Application by Mallard Pass Solar Farm Limited for an Order Granting Development Consent for Mallard Pass Solar Project- EN010127

Submission by John Hughes: ID ref: 20036141

Deadline 2 Written Representation: Substation (APP- 125) & ZTV Figure 6.6 (APP-138), Representative View Points 1 – 20, APP-140 to APP-159, Photomontages A – E, APP 168 to APP – 172,

Drawing file: EN010127 / EN010127-000216-Figure 06.6_Zone of Theoretical Visibility Study Representative Viewpoint and Illustrative Viewpoints.pdf

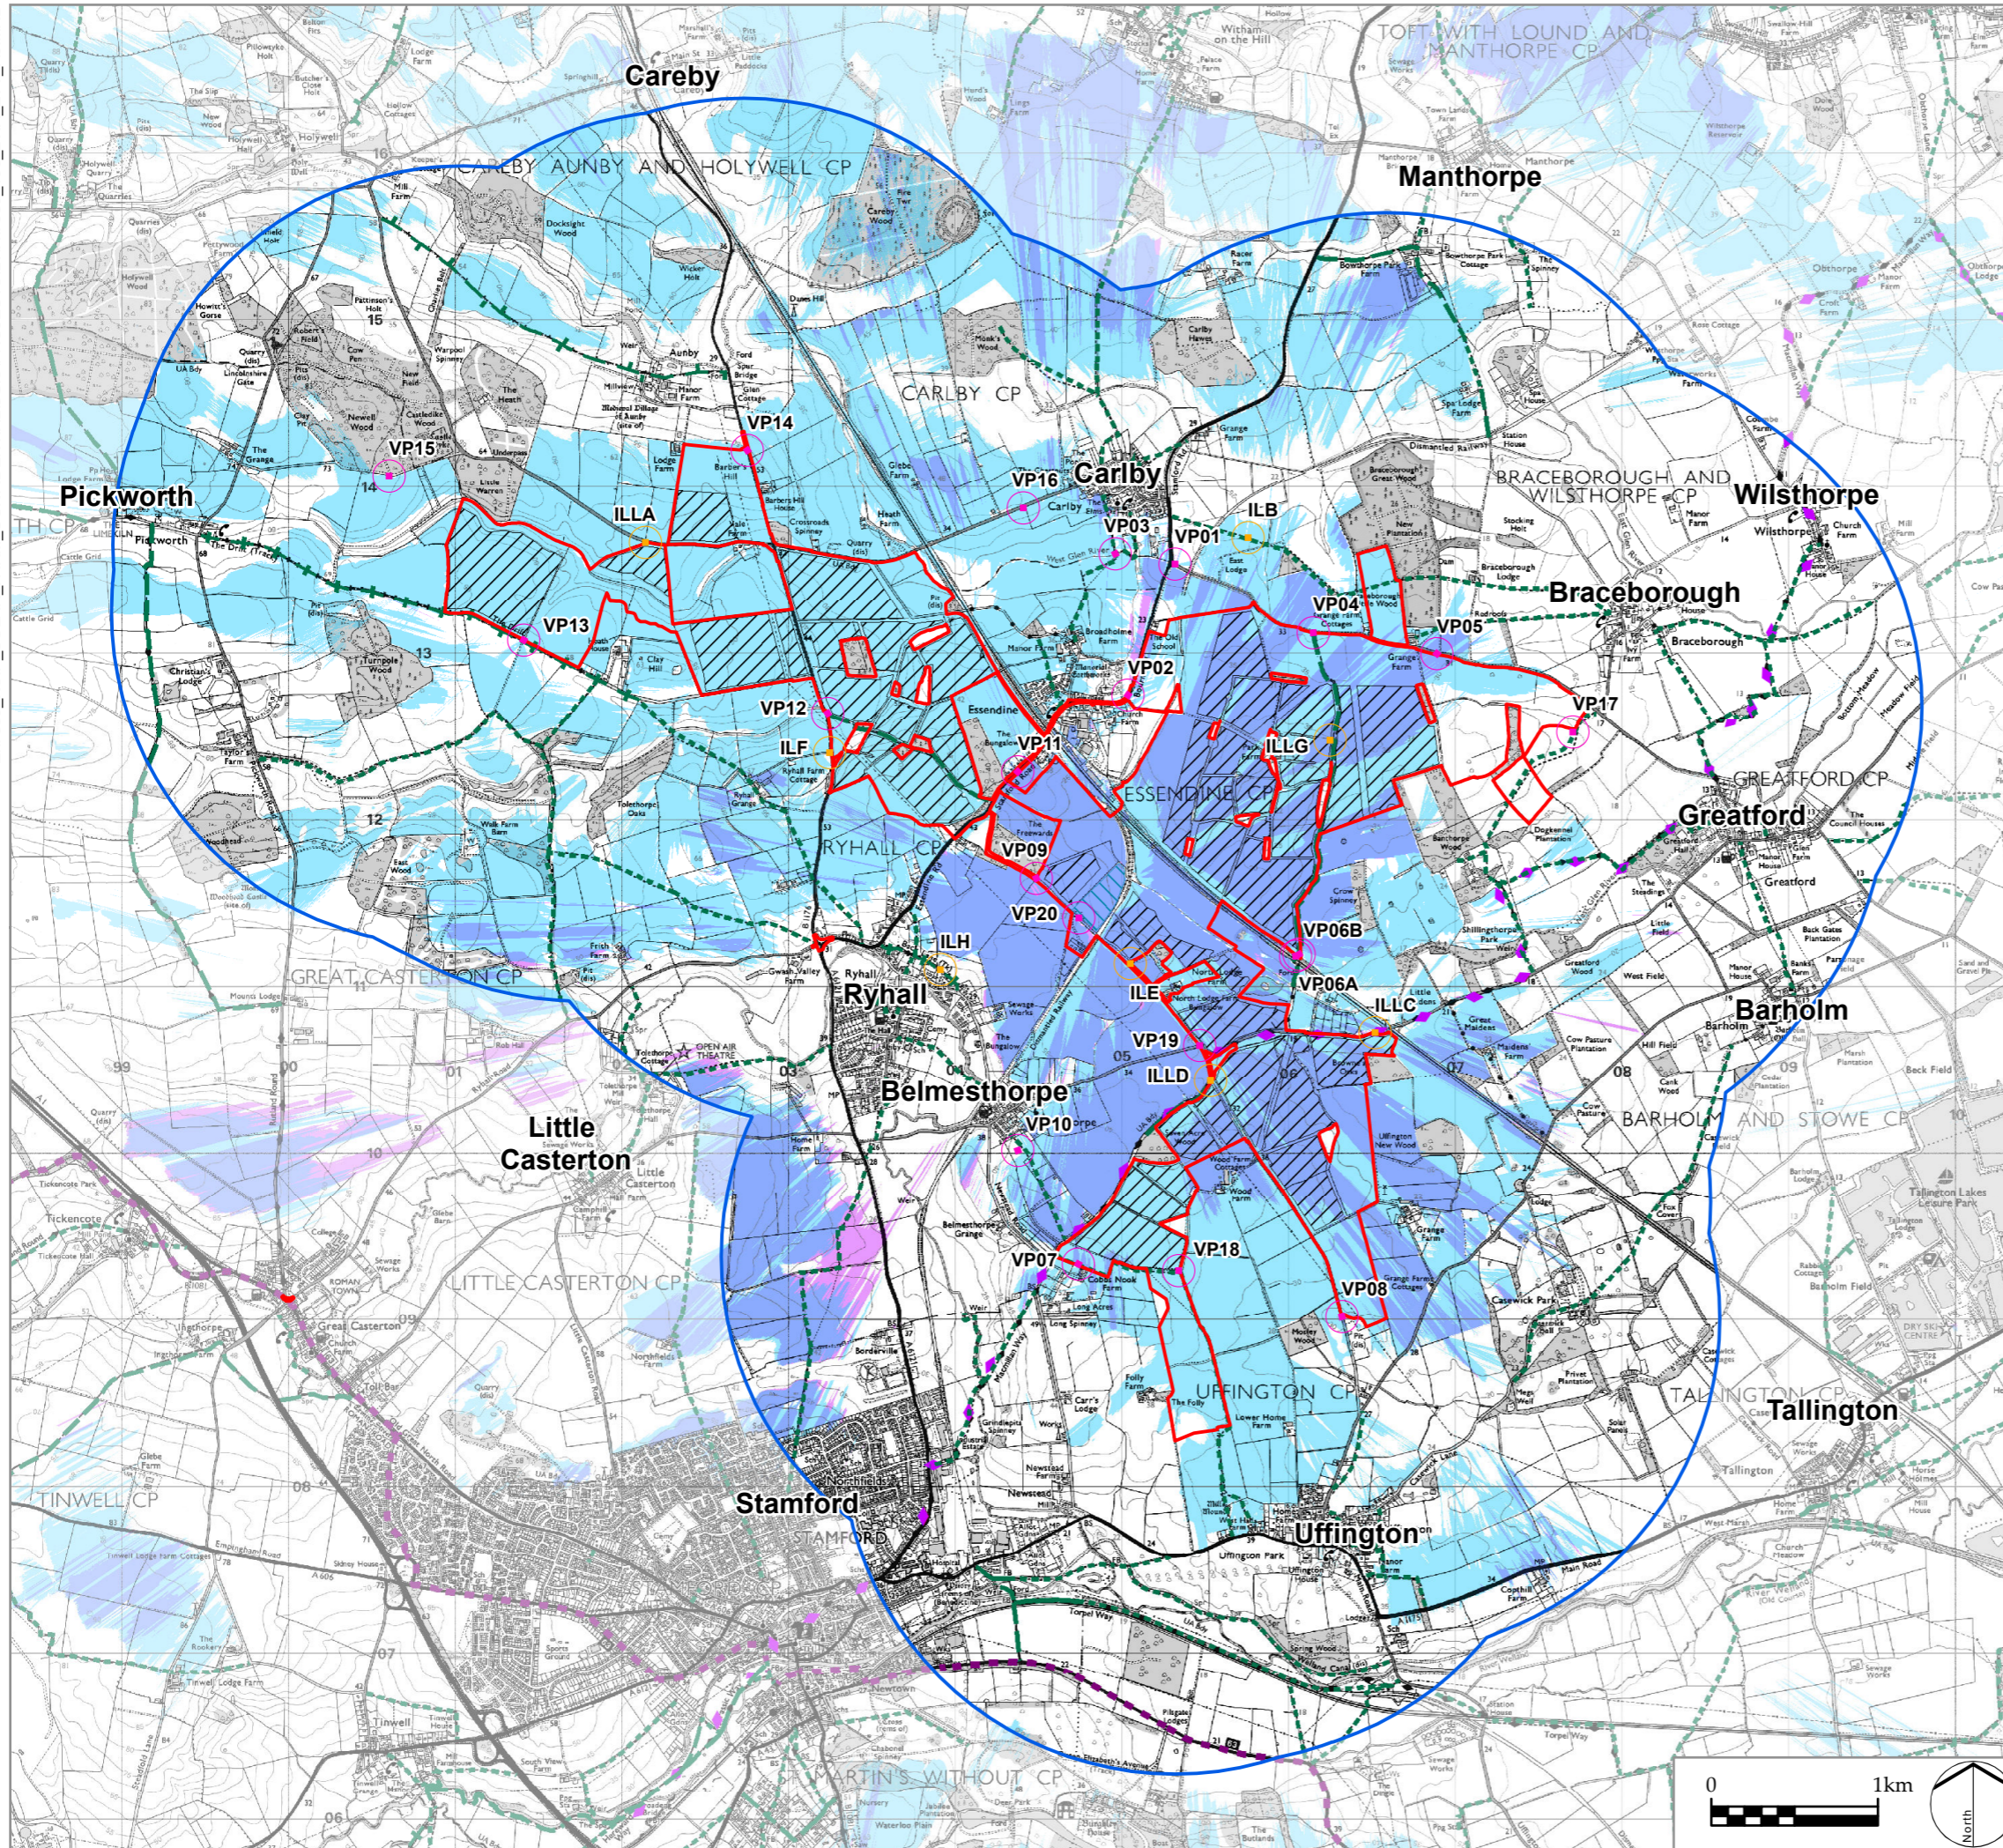
If you zoom into VP11 on the ZTV Figure 6.6 (APP-138) Glen Crescent and the The Bungalows along Stamford road they are not effected by any of the proposed structures, how can this be correct when the current substation can be seen from within the house, garden or footpath along the A6121.

Drawing file: published-documents / EN010127-000129-Appendix 06.4 Residential Visual Amenity Assessment.pdf

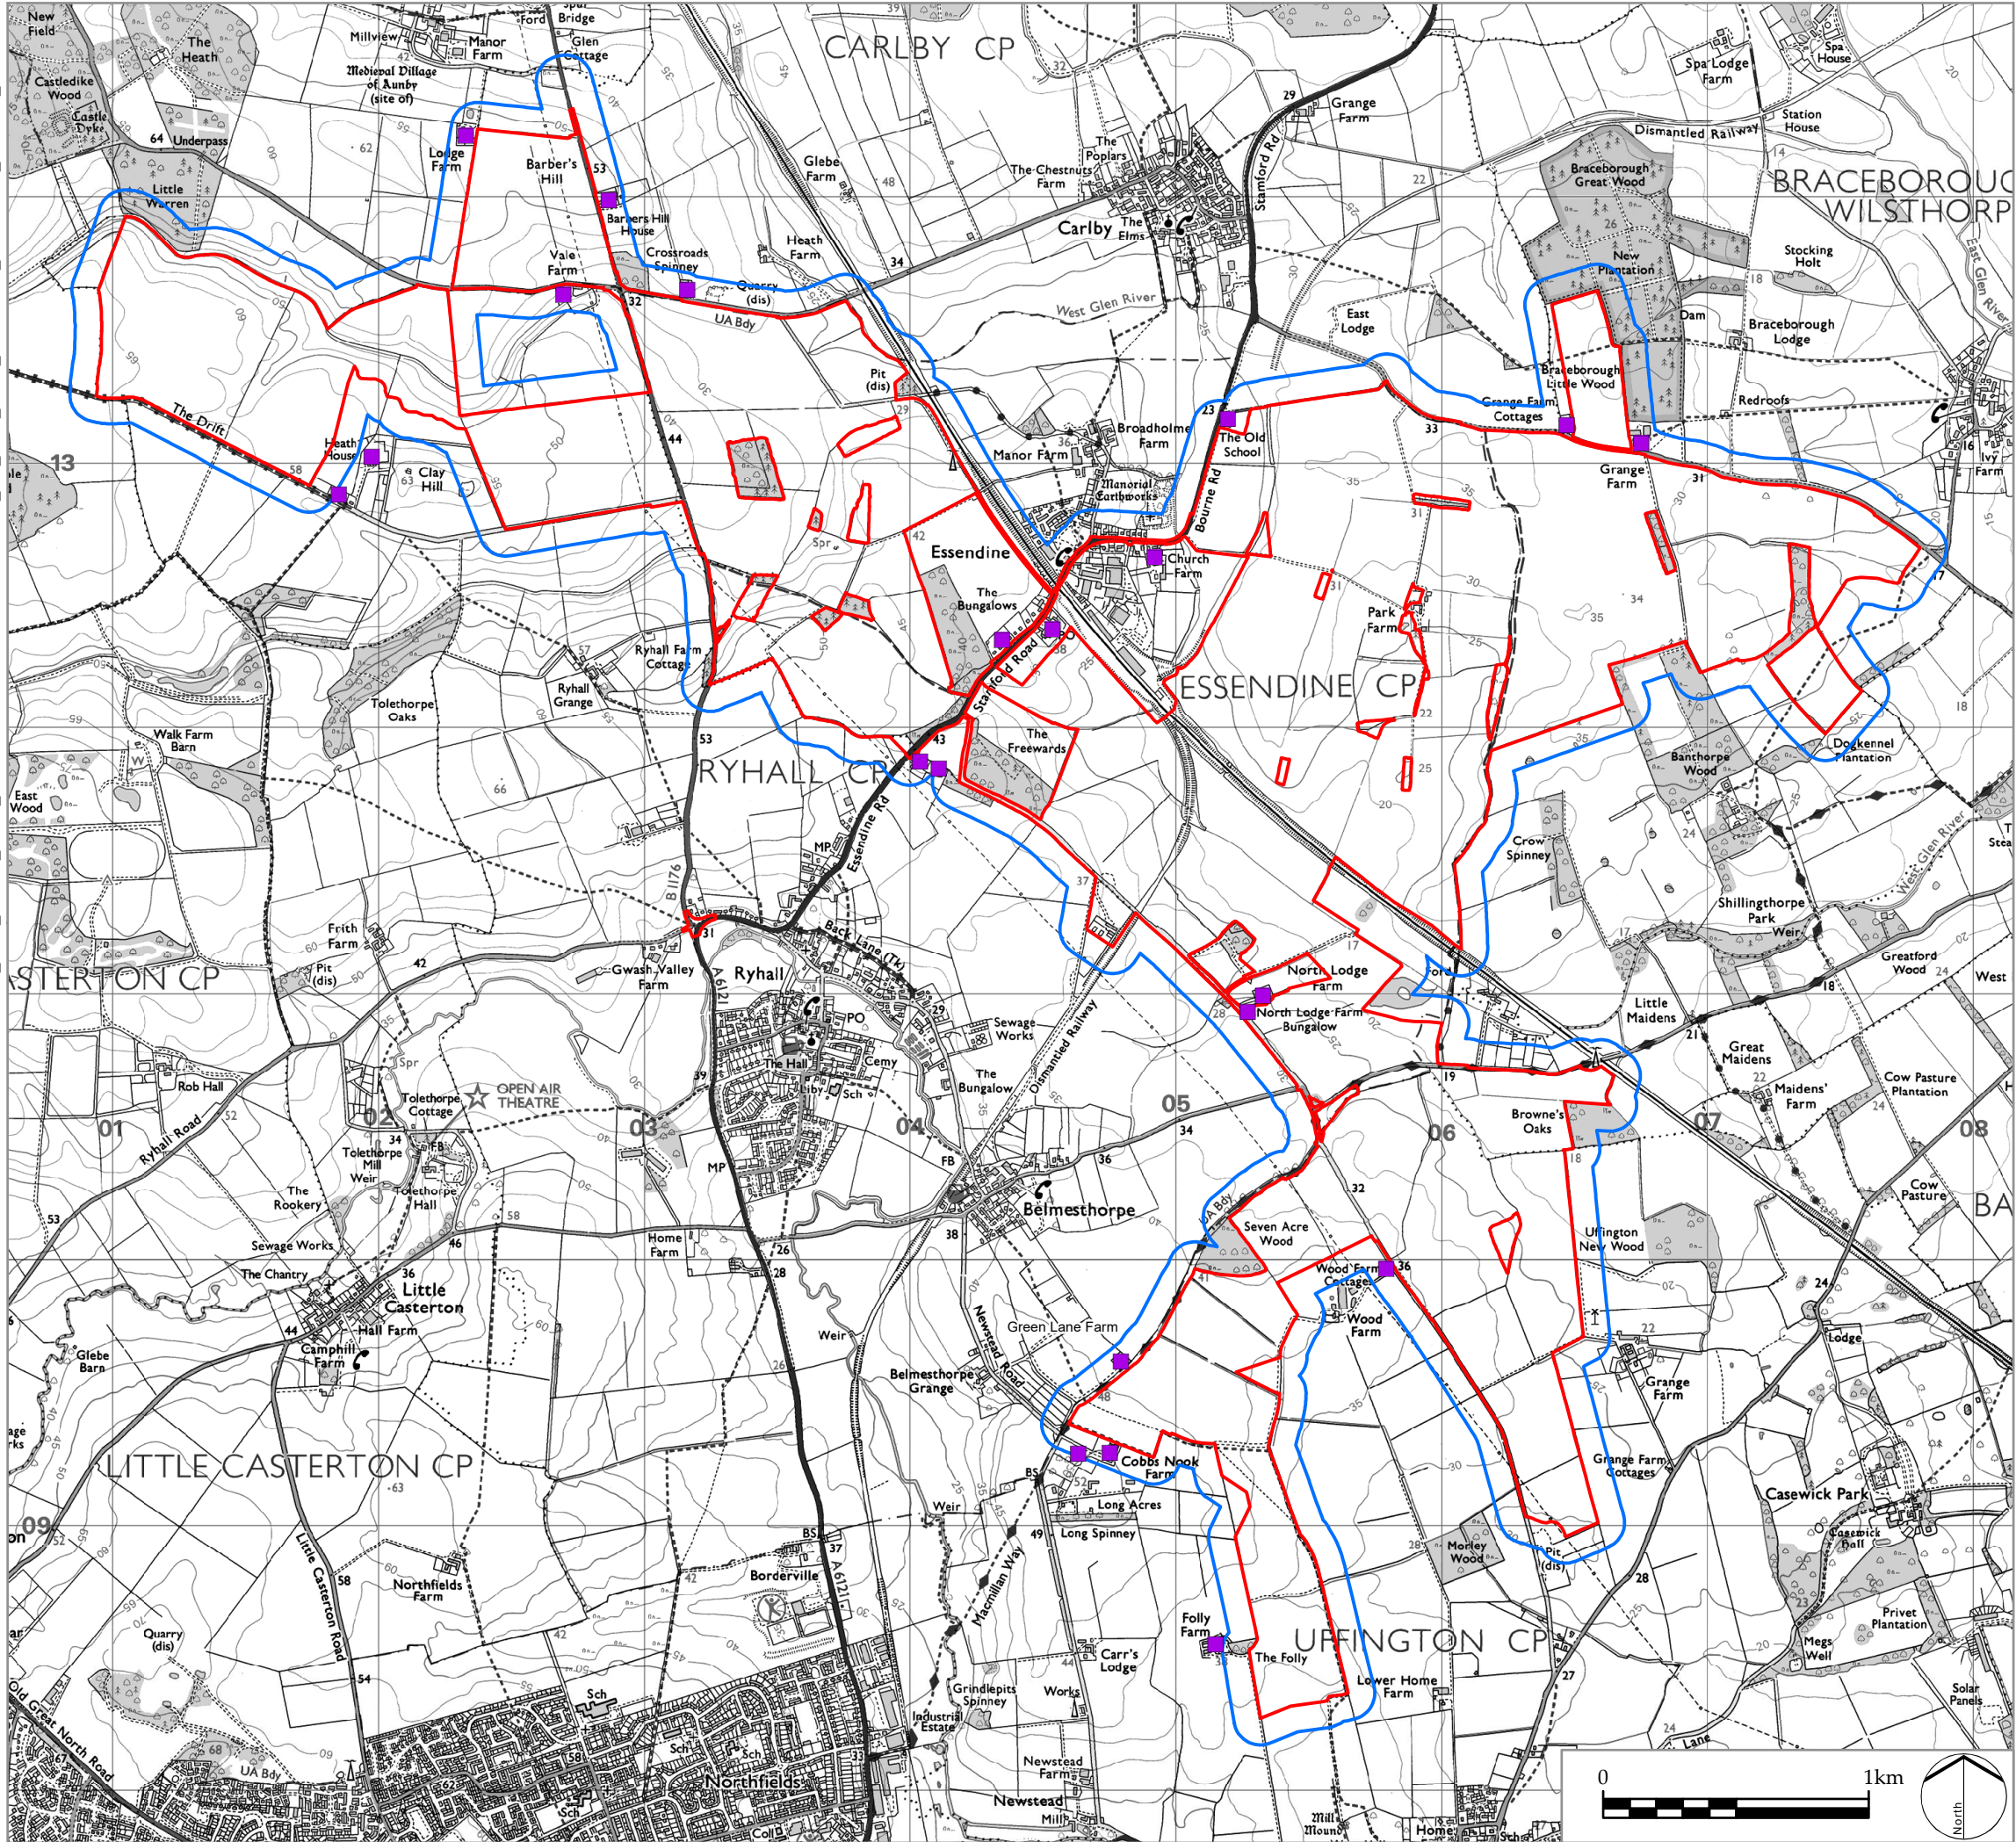
Q. Why in the 'Residential Visual Amenity Assessment' Table 1 in relation to Glen Crescent and The Bungalows in the Magnitude of Change 'Low/Negligible' and the Significance of Effect 'Slight' considering based on current plans both the new substation field 19 and PV arrays in field 18 will be highly visible and not screened by mitigated planting

a) Field 26 falls away from The Bungalows and Glen Crescent from 40m down to 23m (Google Earth)

b) Field 18 rises up from 23m to 39m with its boundry between field 26 & 19 making any PV arrays sited in this field highly visible, mitigated planting would have little effect due to the fields elevation of 16m.

c). Field 19 the current hardcore location is 36m above sea level, the proposed substation at 13m high would take the elevation to 49m and no mitigated planting is considered between field 18 and 19
